Arun District Council
Arun Civic Centre
Maltravers Road
Littlehampton
West Sussex BN17 5LF
Planning & Building Control General Enquiries
Tel: (01903) 737756 Fax: (01903) 730442
Dx: 57406 Littlehampton
Minicom: 01903 732765
e-mail: planning@arun.gov.uk
website: www.arun.gov.uk/planning

Application No: AB/29/21/L
Site Address: 78 Maltravers Street Arundel BN18 9DS
Description of works: Listed building consent to replace windows 2 No. front and 1 No. rear windows.
Replicas of existing design, with 4-4-4 ultra lite glazing, 3 No. box frames with sash.

Drawing
Typical detailed elevation
and section

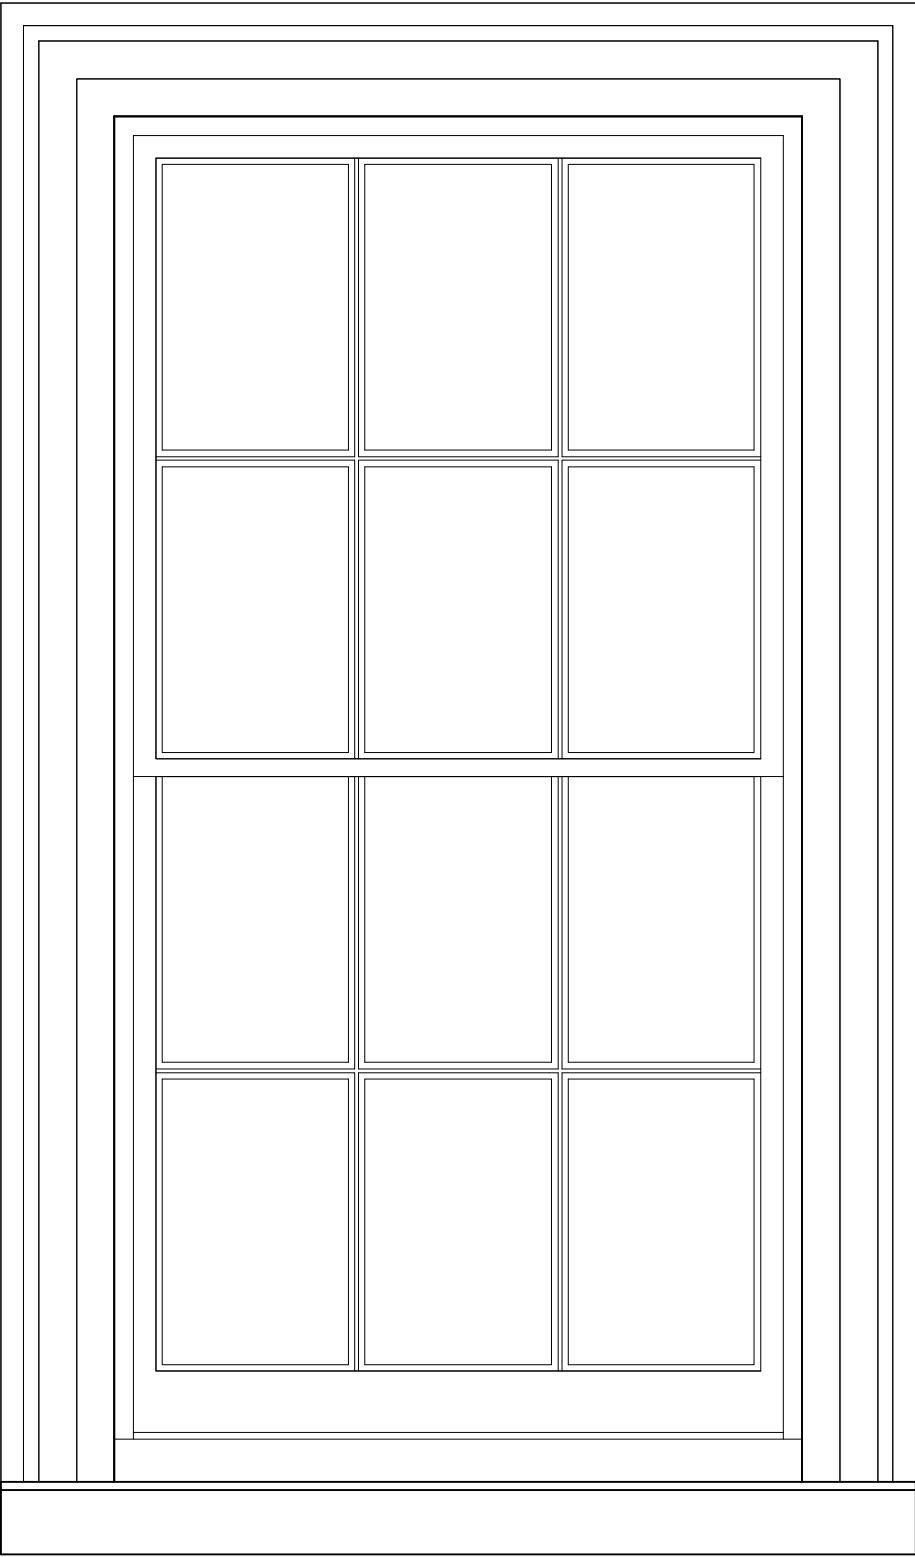
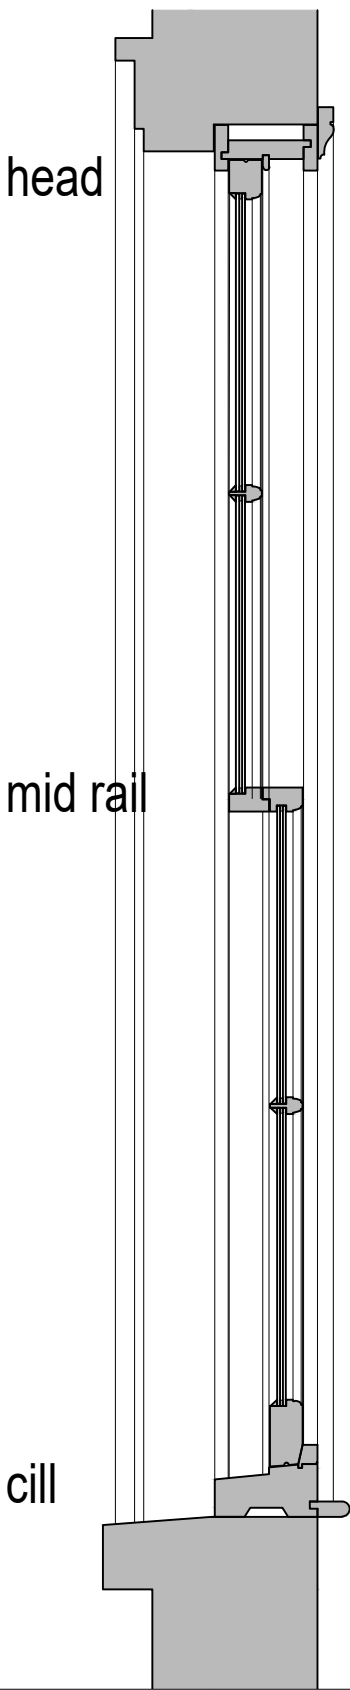
The Committee objected to the application on the grounds that the windows should be in the original style using secondary glazing rather than using replacement double glazing.
